**Consultation Response from KC,
Lead Local Flood Authority**
2020/92657 King James School, St Helen's Gate, Almondbury, Huddersfield, HD4 6SG
Erection of 10 classroom teaching block and formation of car parking area with associated engineering and landscape works (within a Conservation Area)
**Date Responded:
13 October 2020**
**Responding Officer:
Aleksandra Tomczyk**
Responding Ref: 0
Summary

Kirklees Flood Management and Drainage, as the Lead Local Flood Authority (LLFA), OBJECT to this planning application and require FURTHER INFORMATION is provided on the following:

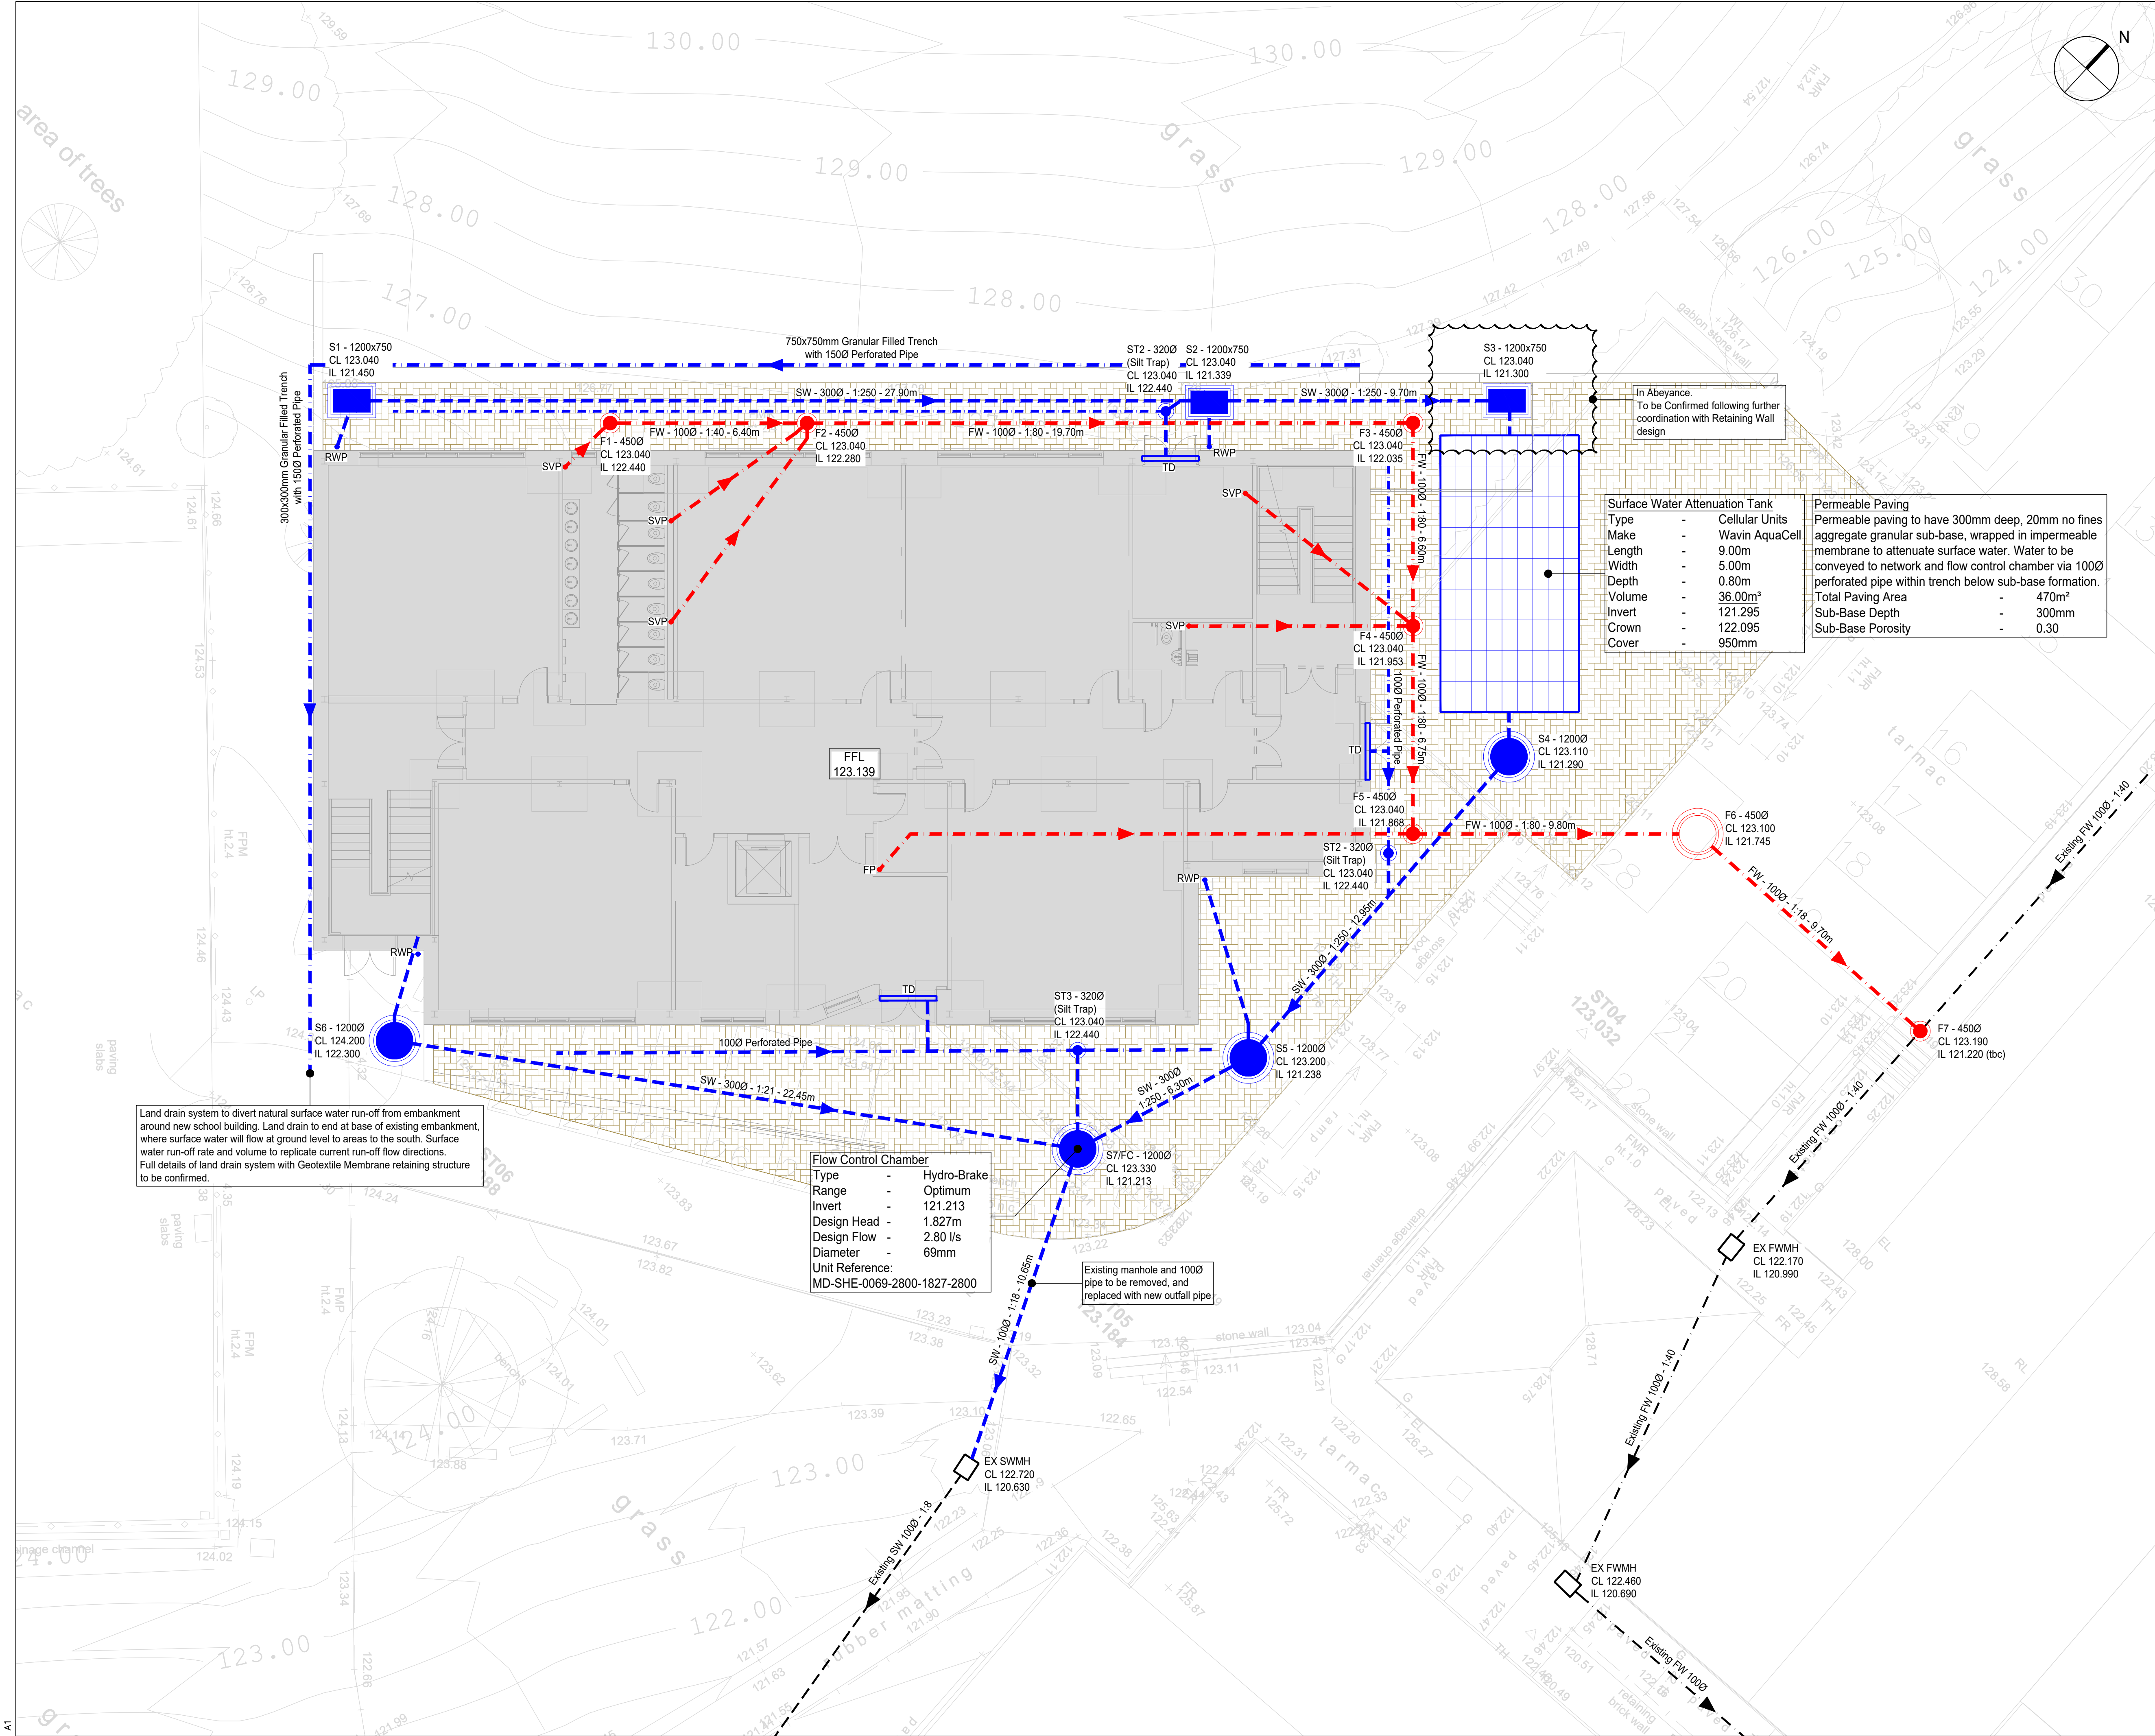
- The applicant proposes to discharge surface water into an existing surface water network within the site boundaries. Kirklees LLFA have **no objection in principle** to this proposal, however, the applicant should carry out investigations to determine the sizing and condition of this system, to ensure that it is able to accept the flows.

- The applicant proposes to discharge surface water at 2.6l/s. Kirklees LLFA **object** to this proposal as such low rate could cause issues with maintenance of the system. The LLFA require the minimum discharge rate to be at 3l/s.

- There are discrepancies between the report and the drawing, with regard to the dimensions and sizing of both attenuation options. This should be reviewed, and updated proposals submitted.

- It appears the attenuation is located approximately in the middle of the system (linearly) and therefore, it is very likely that the pipes and manholes downstream of it will often be surcharged. It would be preferred for the attenuation to be a fully online structure and the flow control to be located adjacent to it.

Figure 3 – EA Pluvial Flood Map

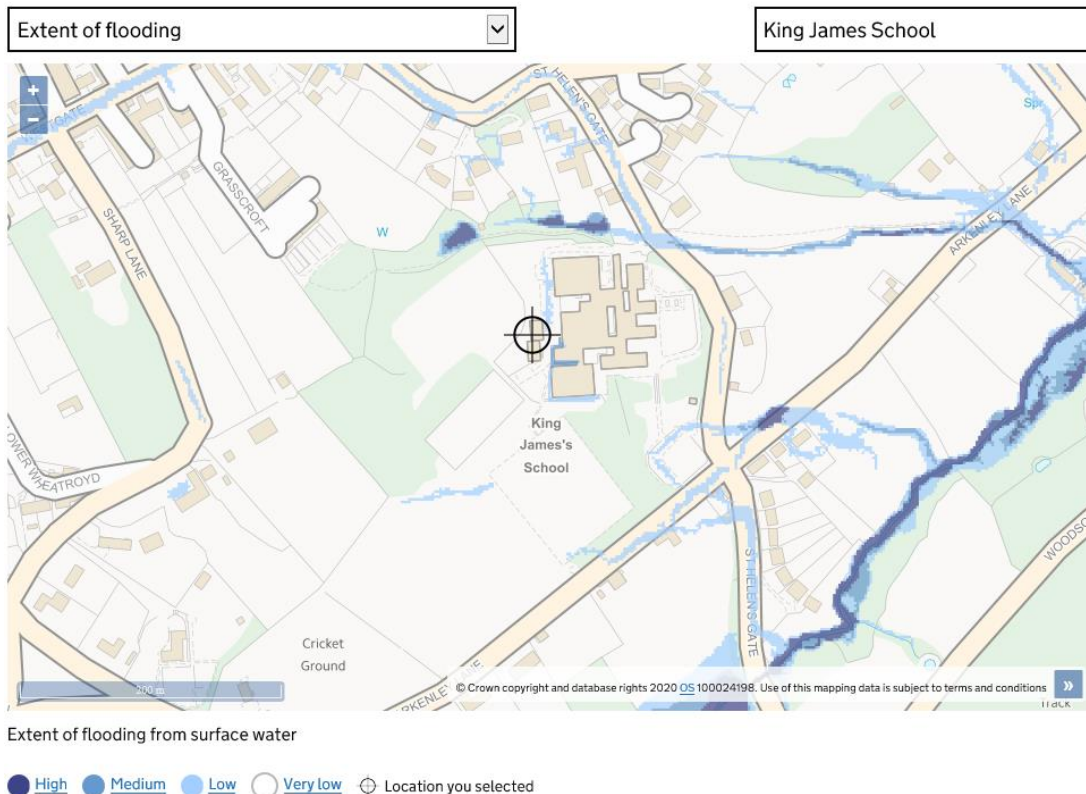
- As stated before, there are some areas of surface water flood risk within the site boundaries. This information should be amended in the document. The applicant should also ensure that the flood risk is not displaced or increased due to the proposals.

18.7. Network Exceedance Event

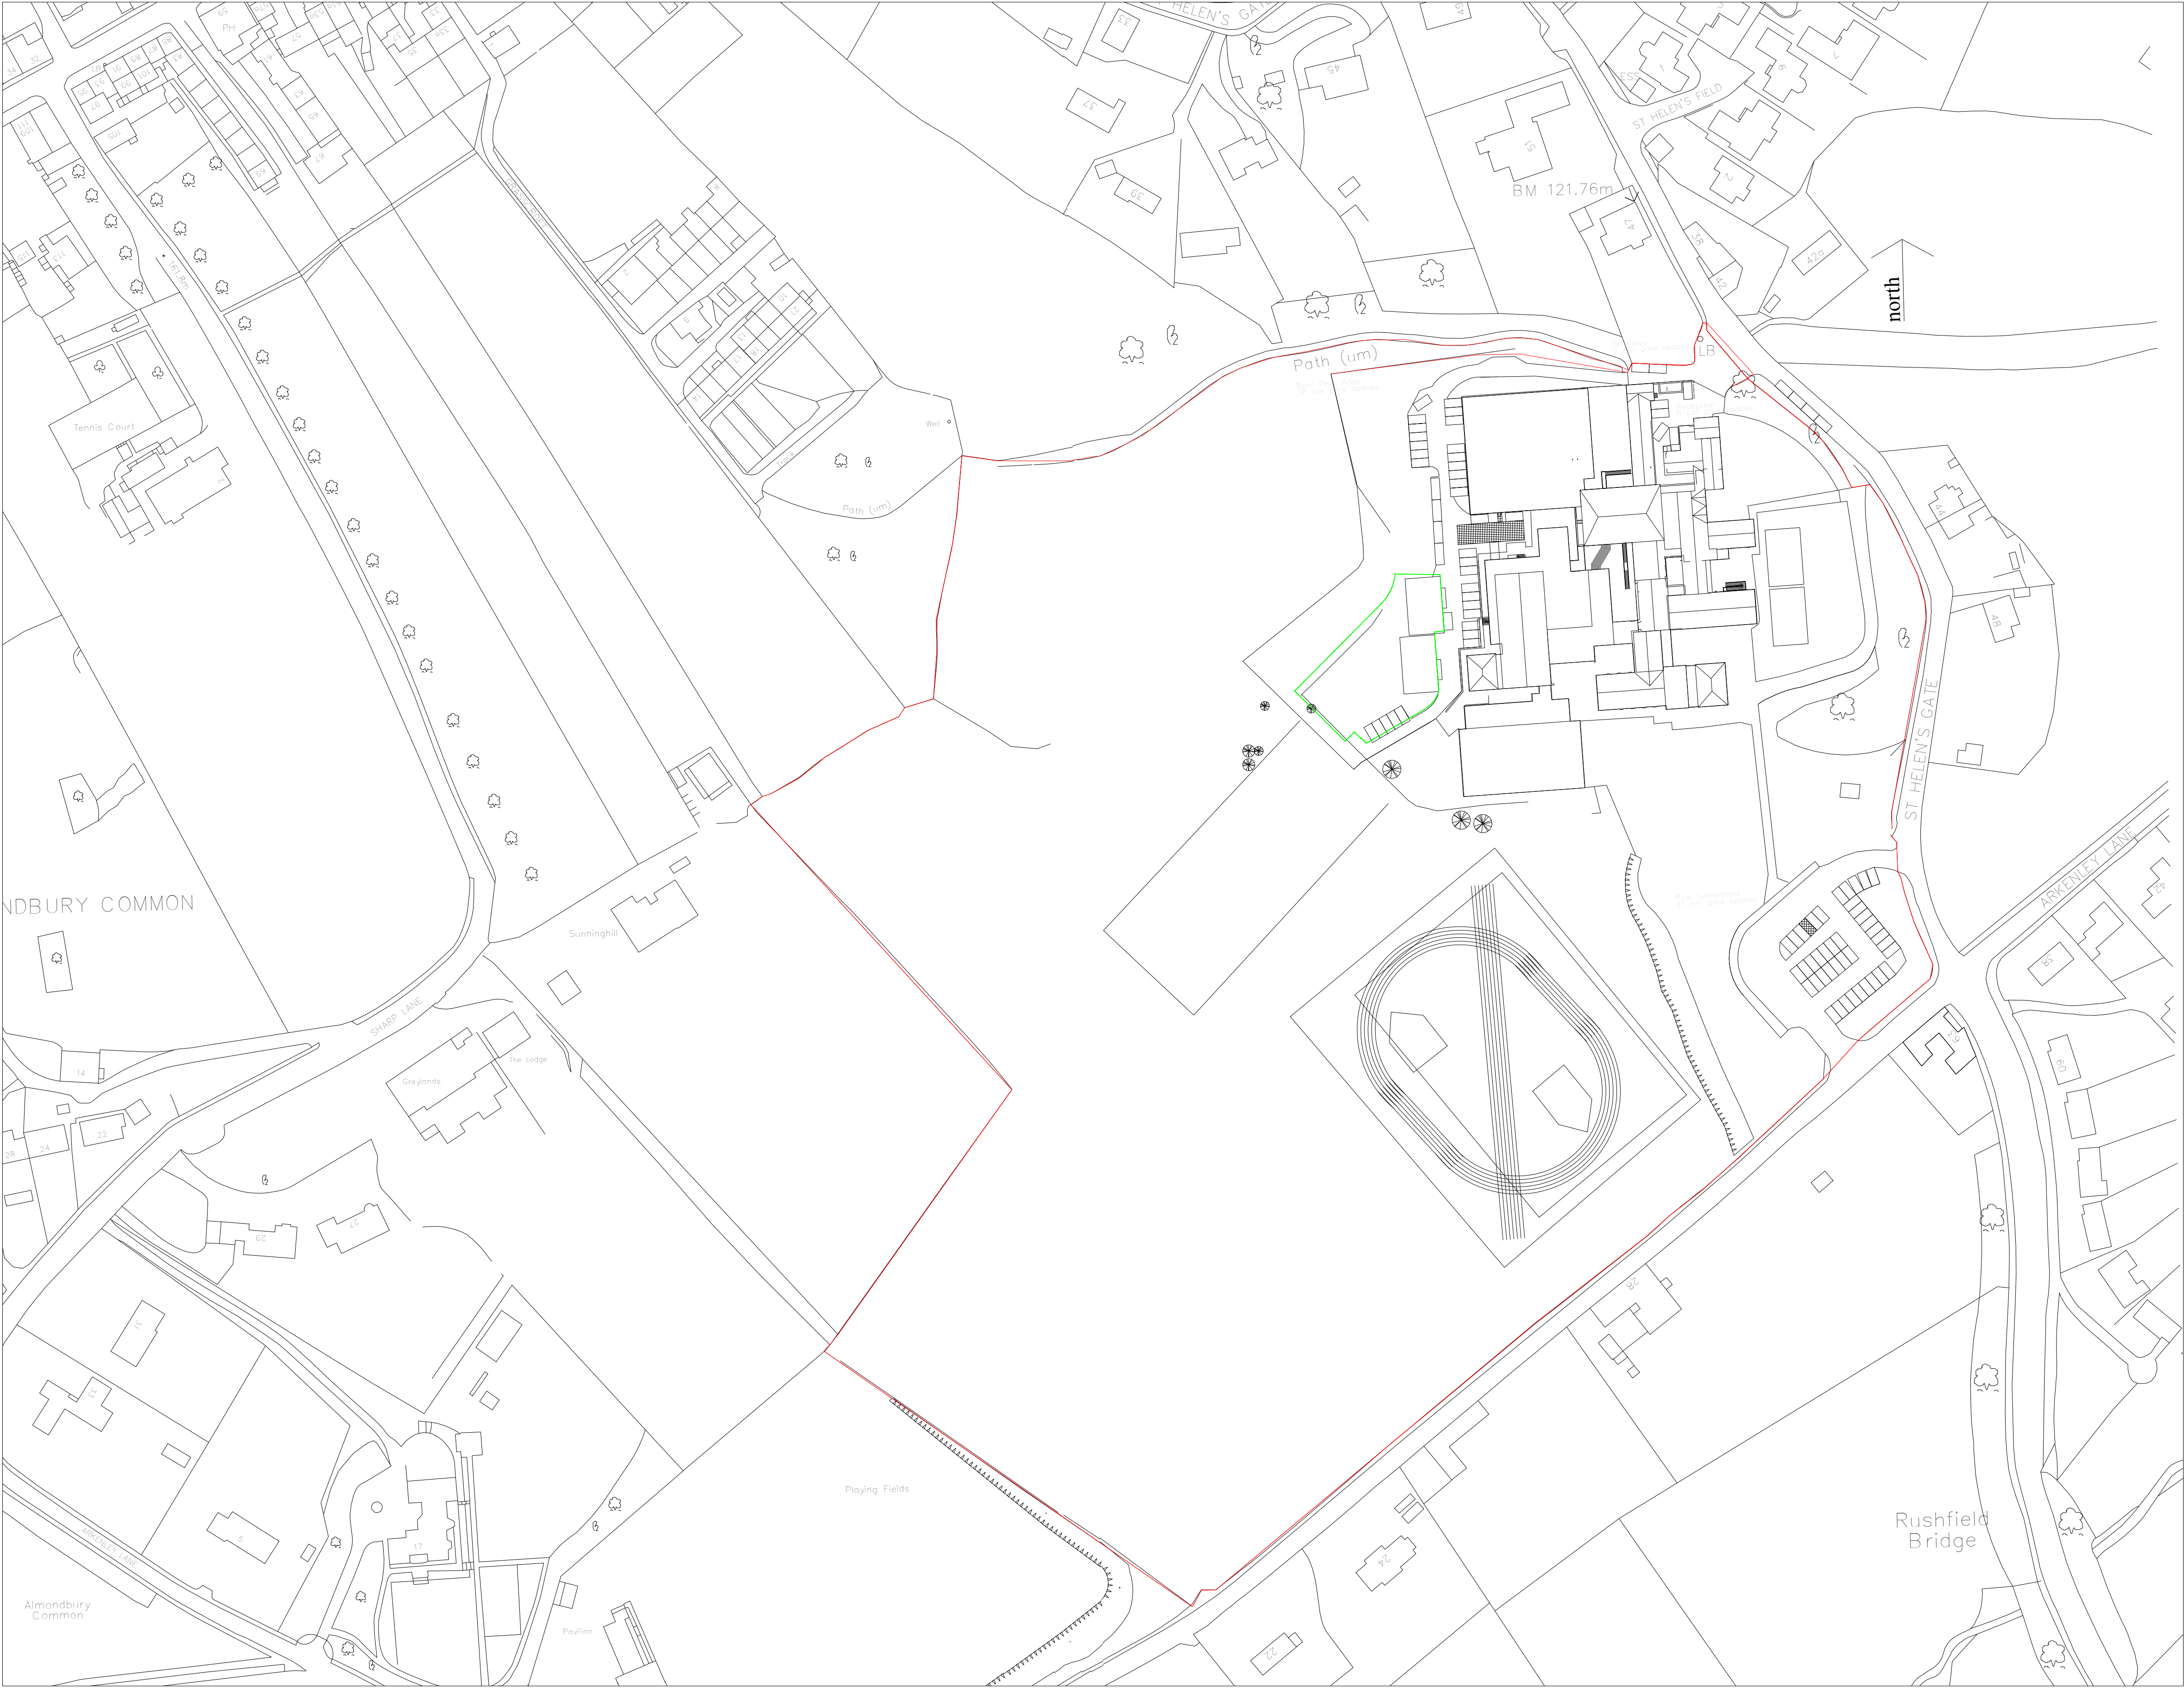
Kirklees LLFA have no objection in principle to the assessment of the overland flows, as described in section 8.8 and shown in Appendix H. However, this assessment fails to include any drainage or flows from the proposed car park area. This should be provided for review.

PERMEABLE PAVING
DRAINAGE DETAIL

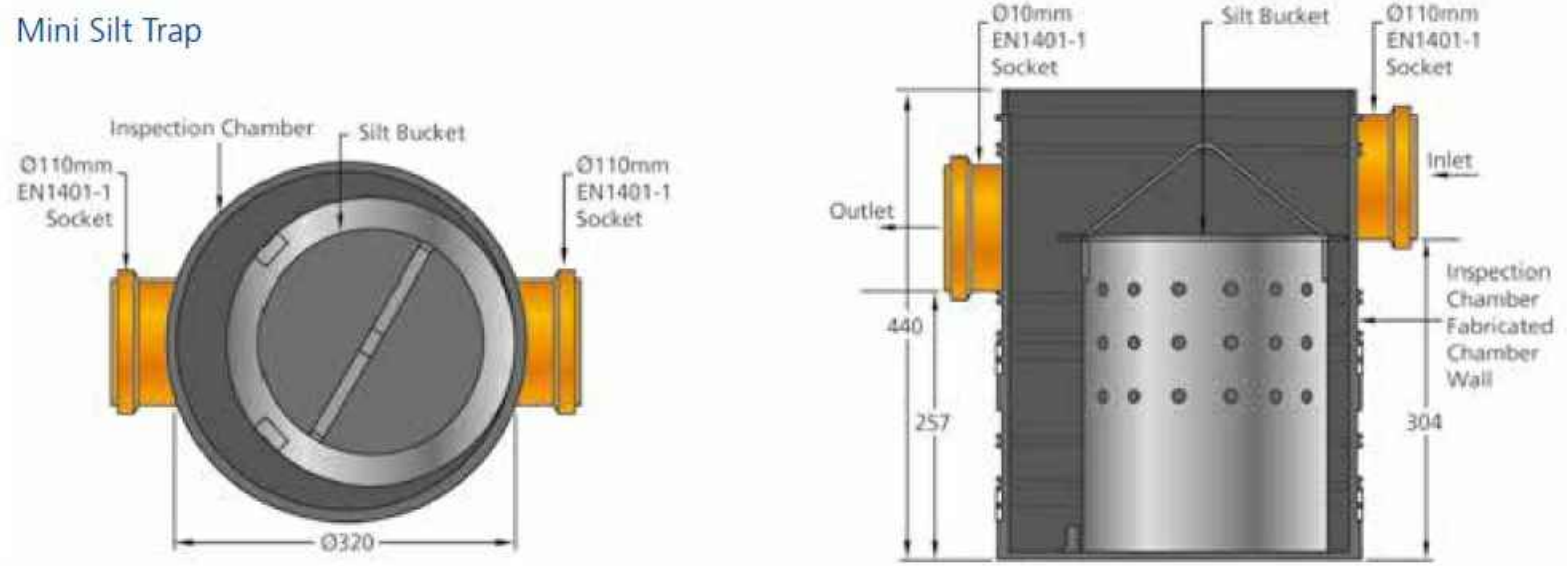
- Management and maintenance plan for the permeable paving, as shown in section 14.3, is considered insufficient to maintain the void ratio required to provide long term attenuation. The applicant should provide high pressure jetting of the pavement at regular intervals, in addition to the steps outlined in the report already.
